June 8, 2018

Re: Les Schwab Tire Center – Falcon, CO – Replat – VR-18-004 – First Review Comments

MERIDIAN CROSSING FILING NO. 1A

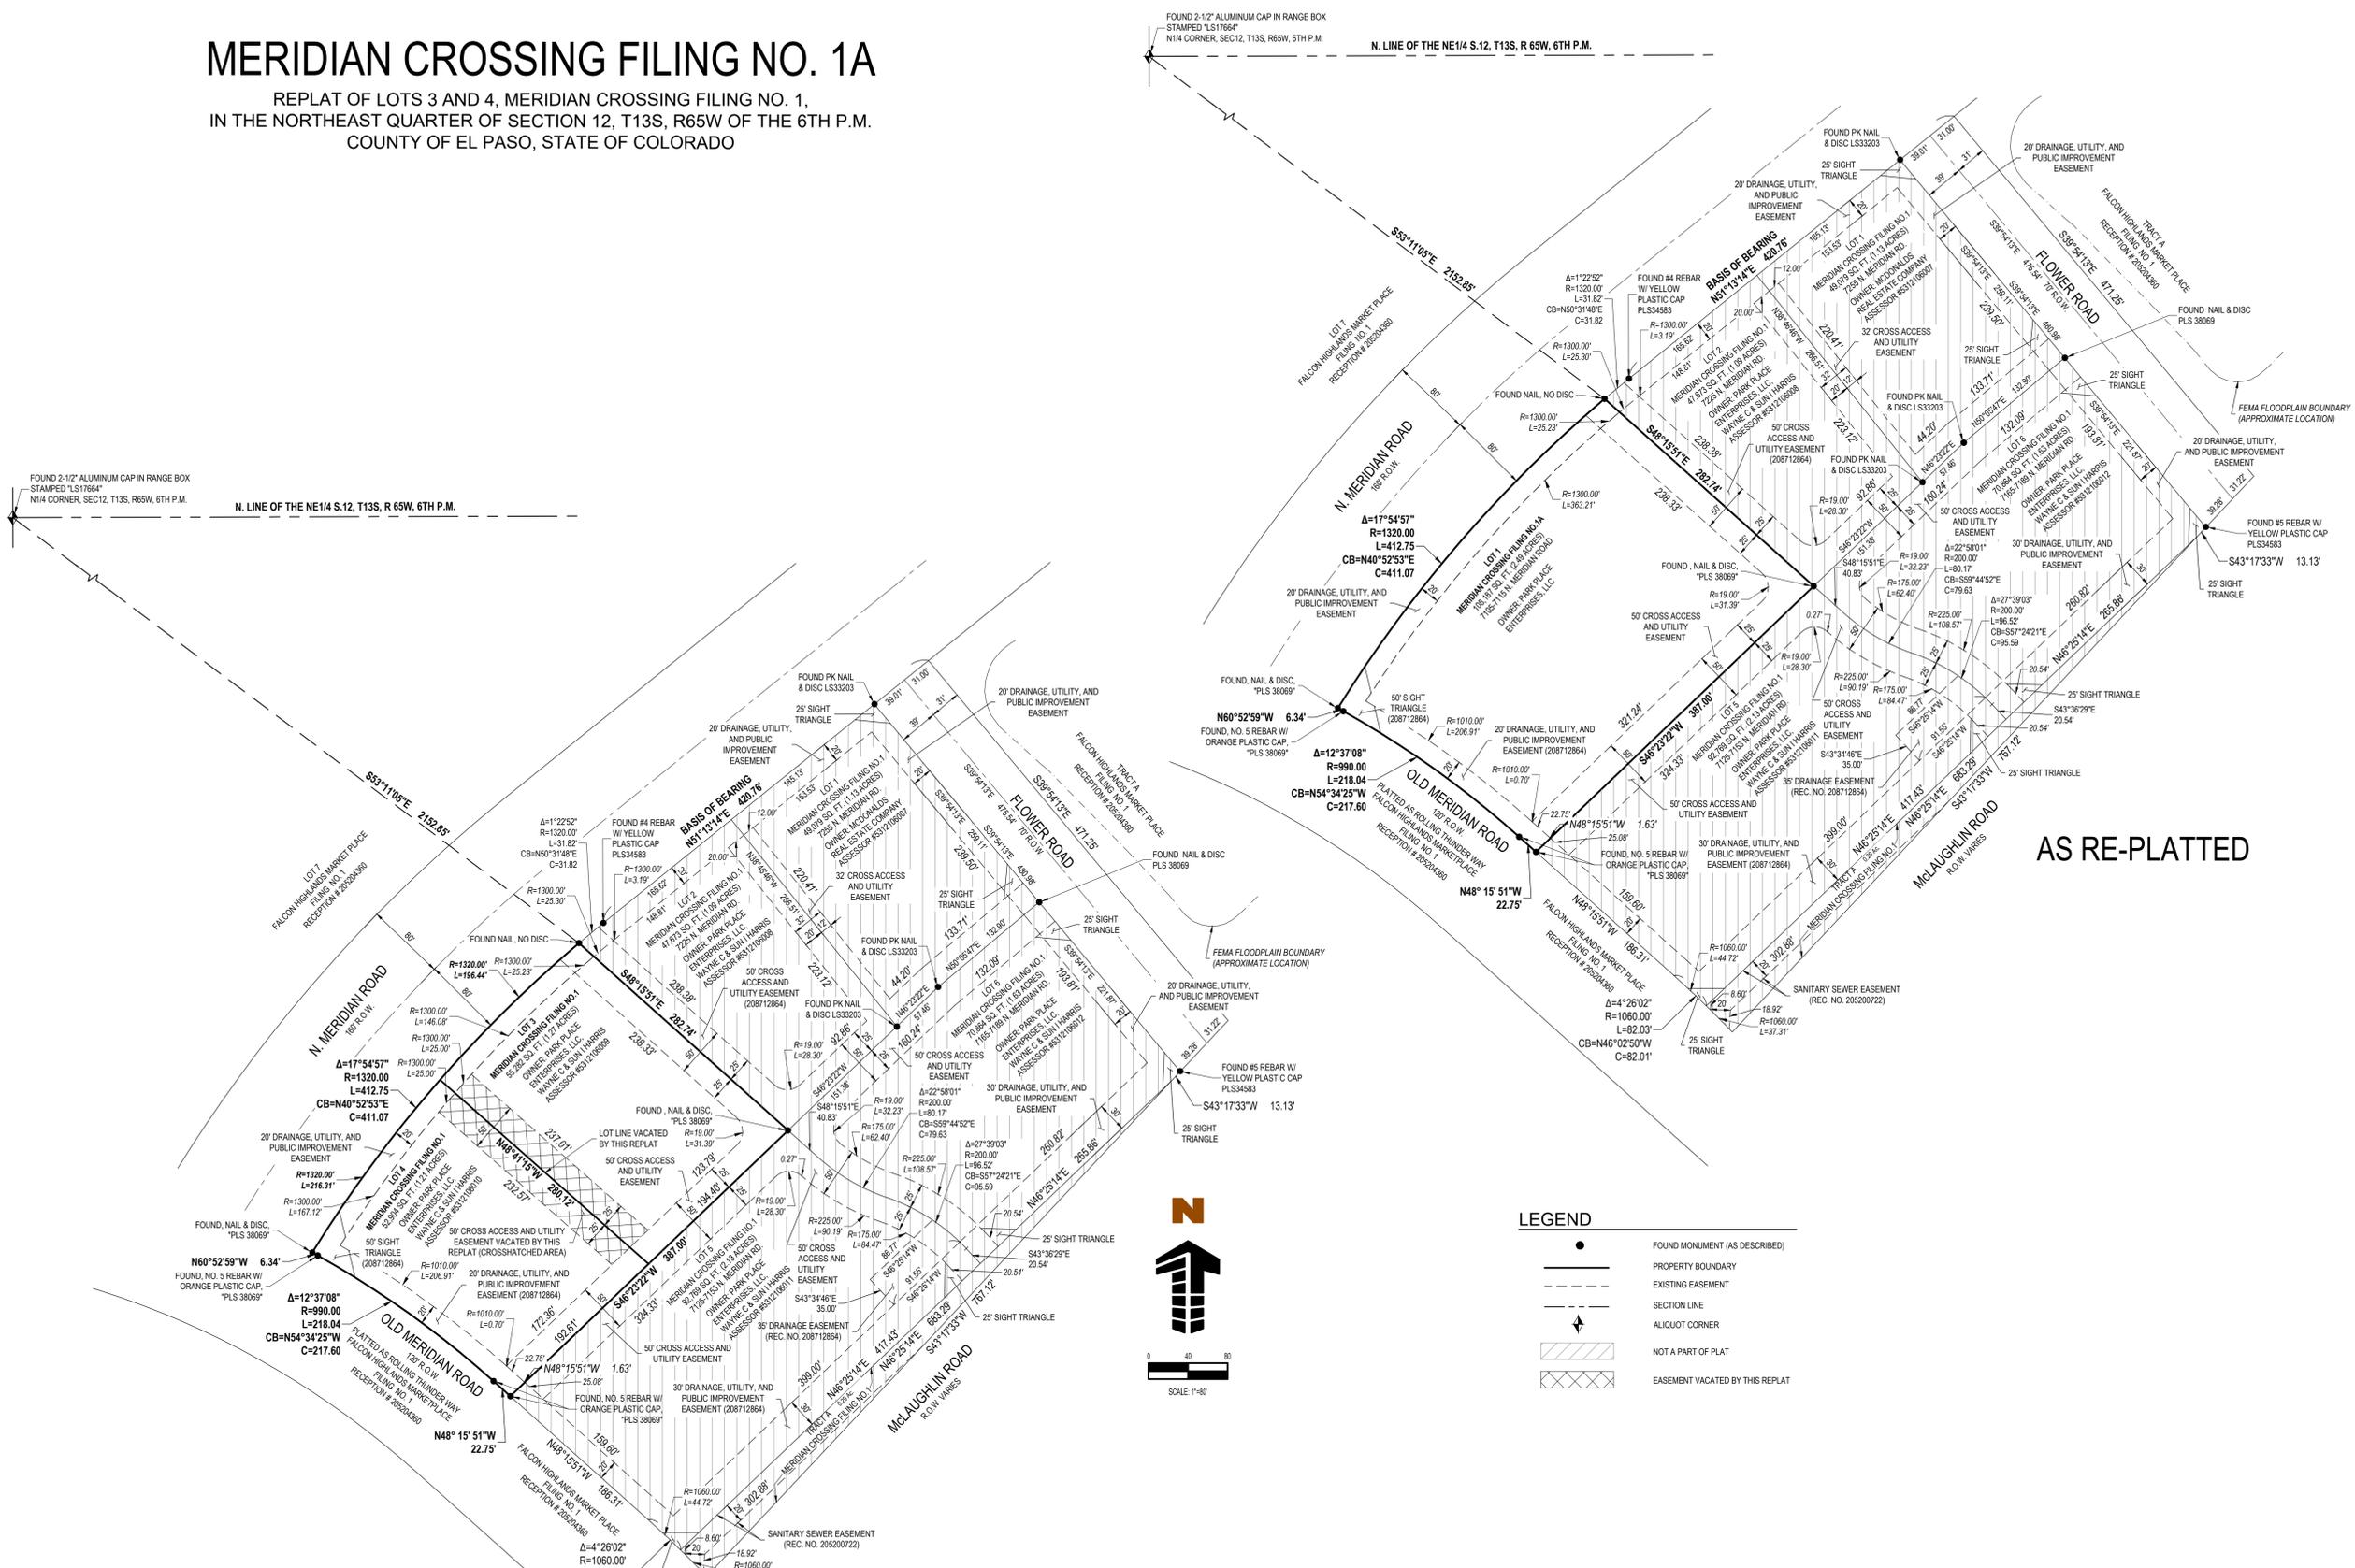
- *On the AS RE-PLATTED all lot numbers new and old should be noted on the lots with the subdivision name*

- *Since The floodplain rate map number listed on the plat is incorrect, should be 0841C0575F-not 765F.*

Response: Revised as requested, thank you.

Response: Revised as requested, thank you.
